Recommendation Report for Planning Permission for Works or Extension to a Dwelling

REF NO: WA/41/22/HH

LOCATION: Aylings Cottage
West Walberton Lane
Walberton
BN18 0QF

PROPOSAL: Removal of existing rear projection and erection of single storey rear extension. This application affects the character and appearance of the Walberton Green Conservation Area.

sheet 1 of 3

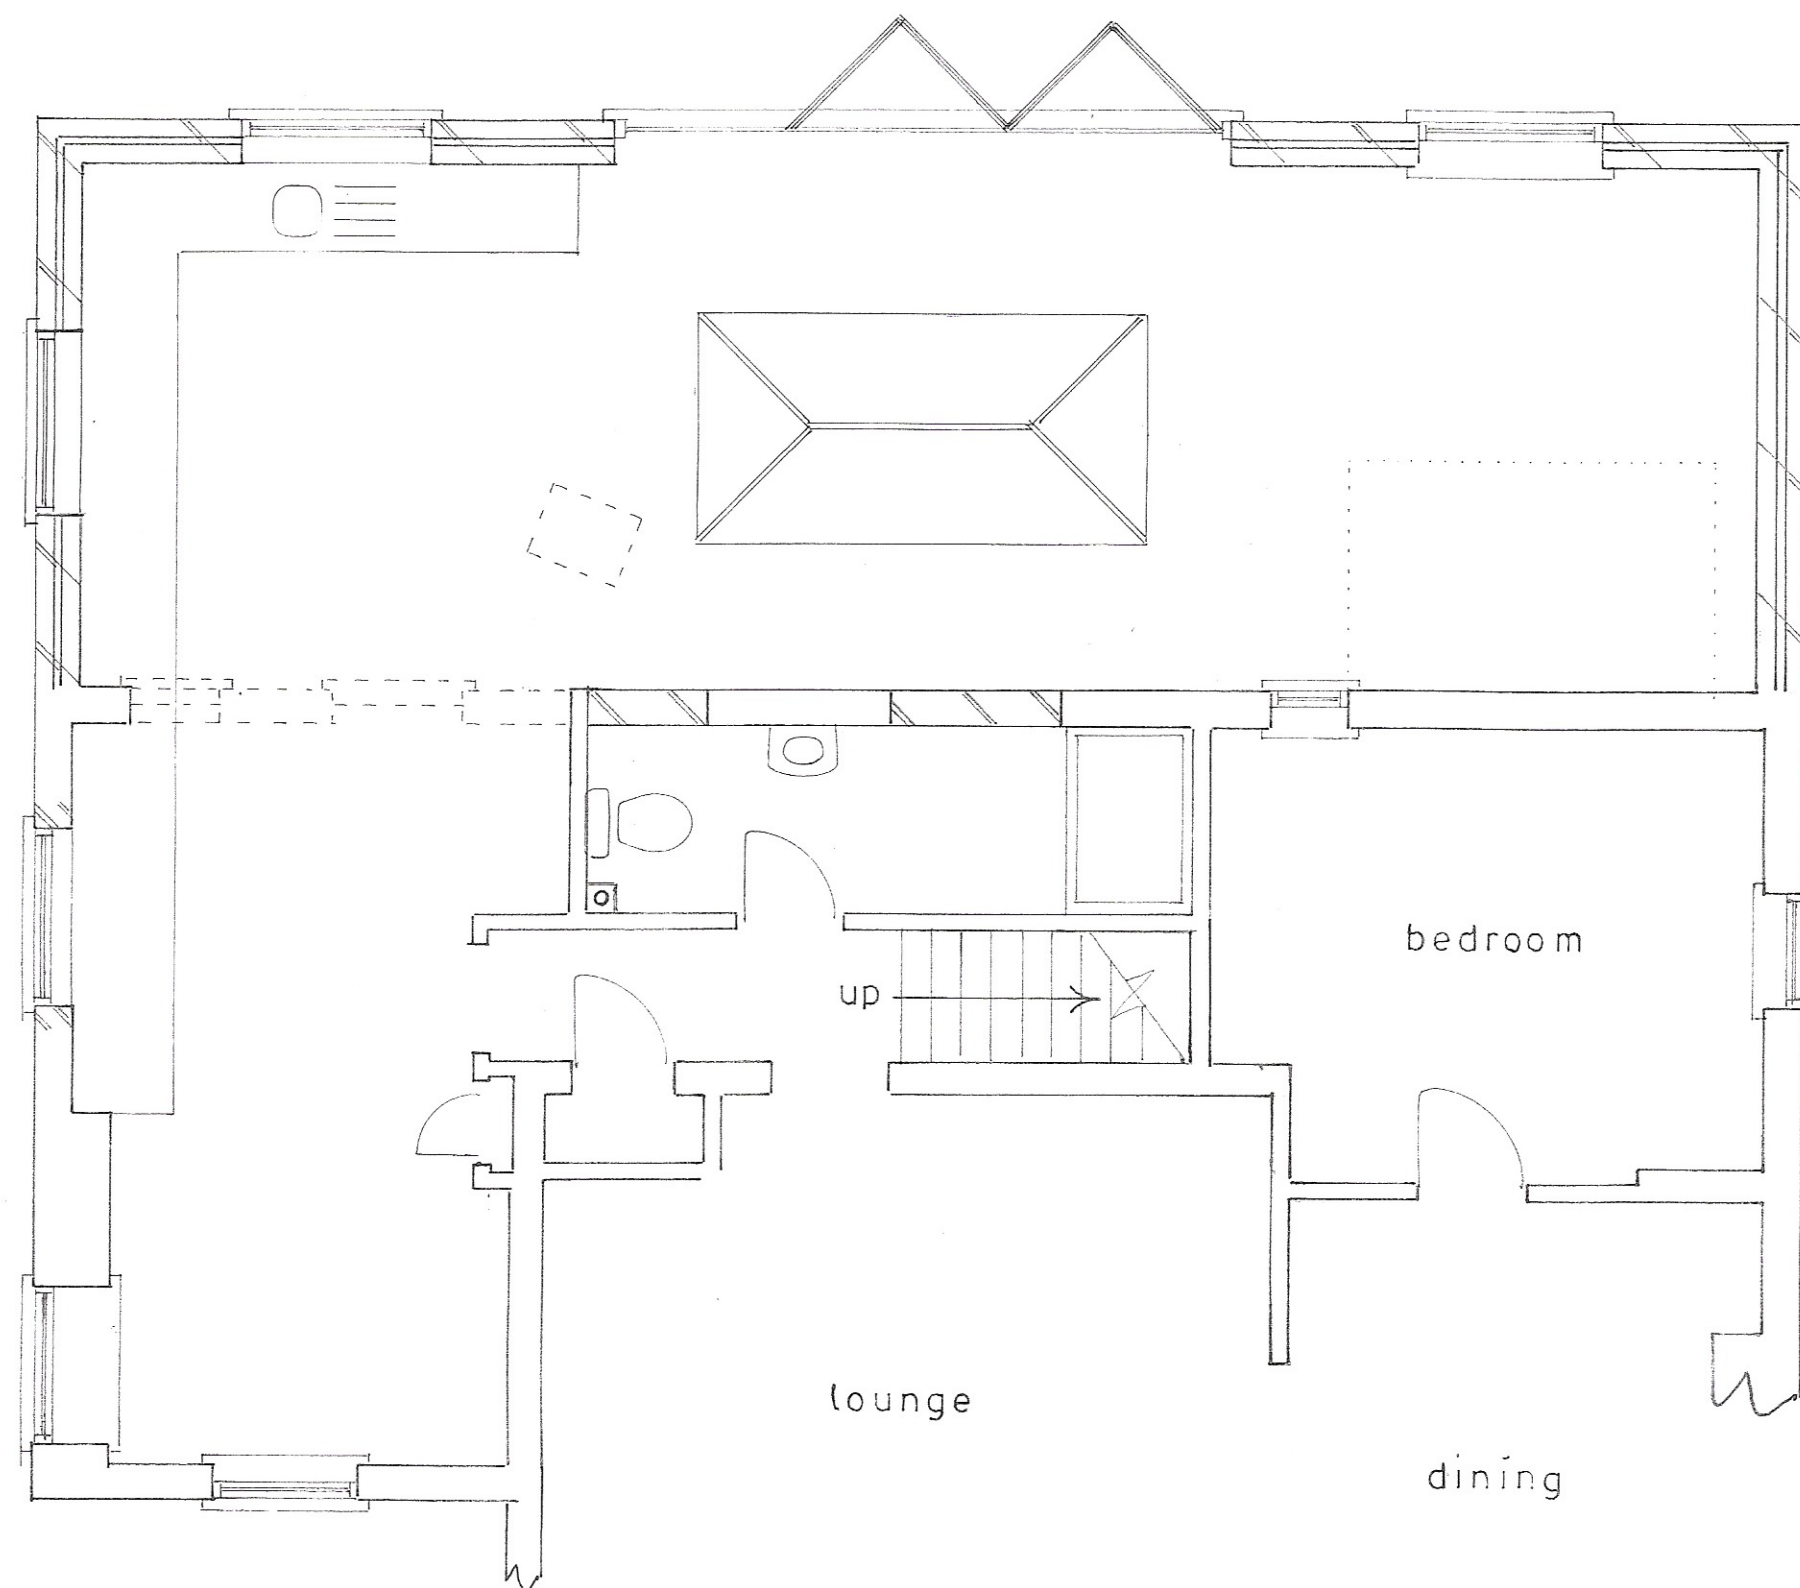
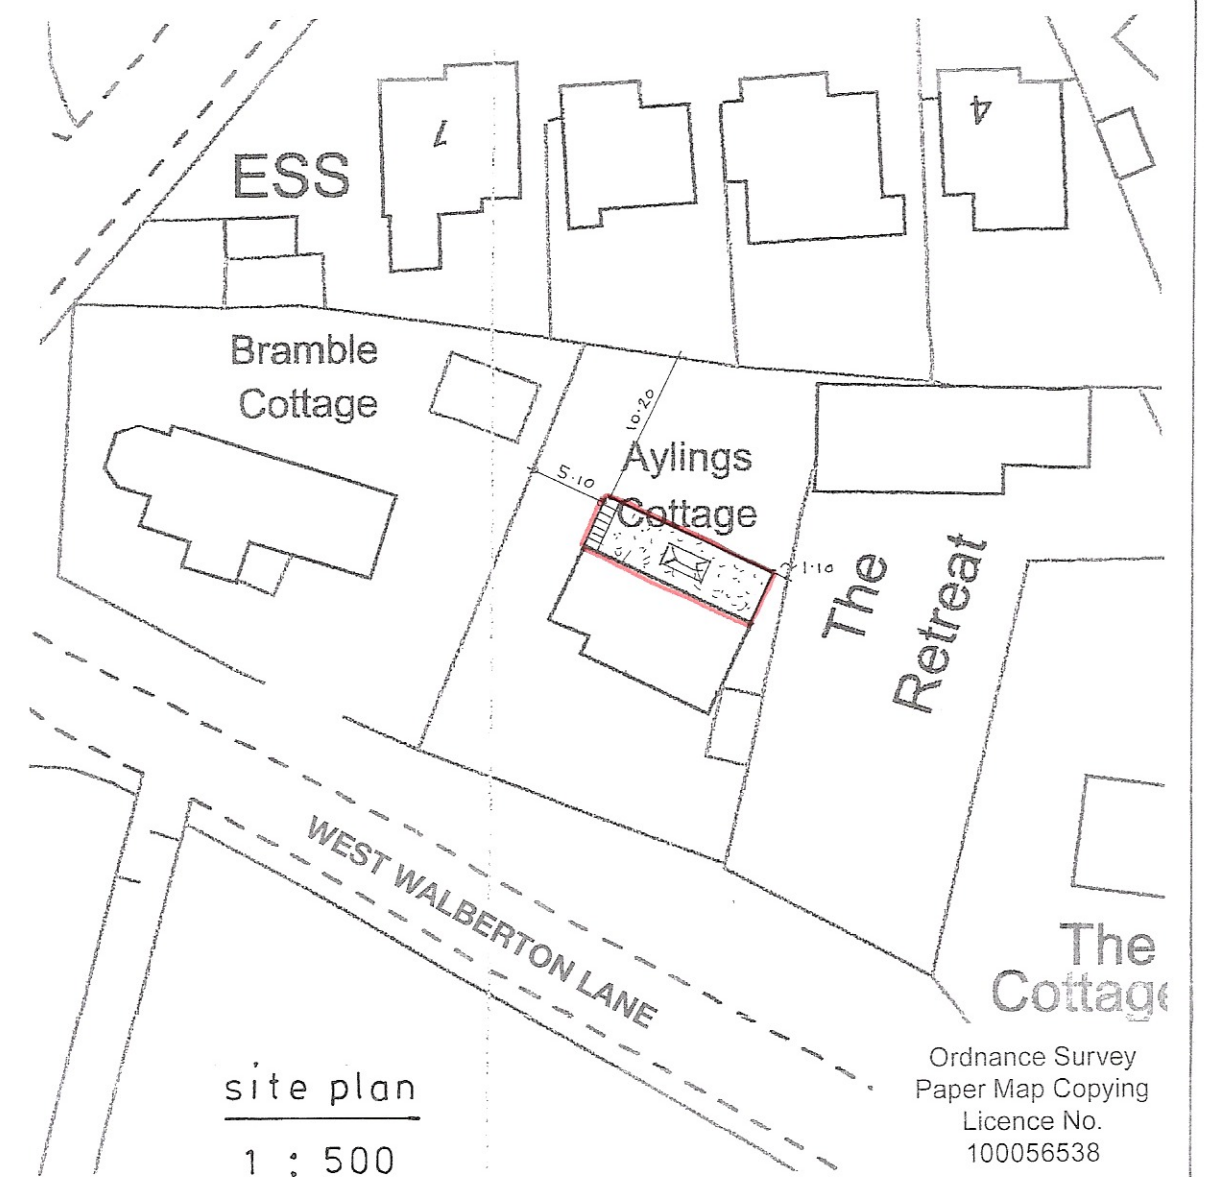
The proposed rear extension is to be single-storey, 3.8m in depth, 11.7m in width and 2.7m in height. It is to feature a flat top roof design with eaves of the West elevation at 2.2m and 1 No. roof light central to the roof. The scale of the proposal is moderate relative to the host dwelling but remains visually subservient. It is also to feature appropriate materials matching those found on the existing dwelling. These are to be colourwash brickwork and matching roof tiles. The proposal is visually integrated.

The proposal includes 4 No. rear bi-fold glass doors and 2 No. rear facing windows. These are to be at ground floor level and lookout to the rear amenity space. As such, they give no rise to any adverse impacts by way of overlooking.

The extension will feature 1 No. side facing window on the West elevation. This is to be at ground floor level at will look out to the side amenity space and boundary treatment. It will not give any rise to adverse impacts of overlooking on any neighbouring properties.
